Longfield Solar Farm

Statement of Common Ground – Environment Agency

Document Reference: EN010118/EX/8.4(B)

November 2022

Figure 3 : SFRA Fluvial Flood Zone Mapping 65% Climate Change - Fluvial Modelling Report

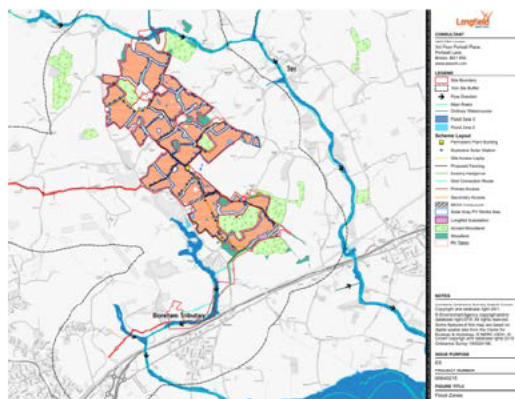
12	Development areas and Flood Zones	Appendix A of the FRA shows the layout of the development. It should also have a map showing built development in relation to the flood zones (including climate change, for the lifetime of development and beyond, as a sensitivity test). [Statutory consultation]	The updated FRA is available in Appendix 9A Flood Risk Assessment [EN010118/APP/6.2] . Figure 3 shows areas where above ground development may be located in relation to Flood Zones.	Agreed
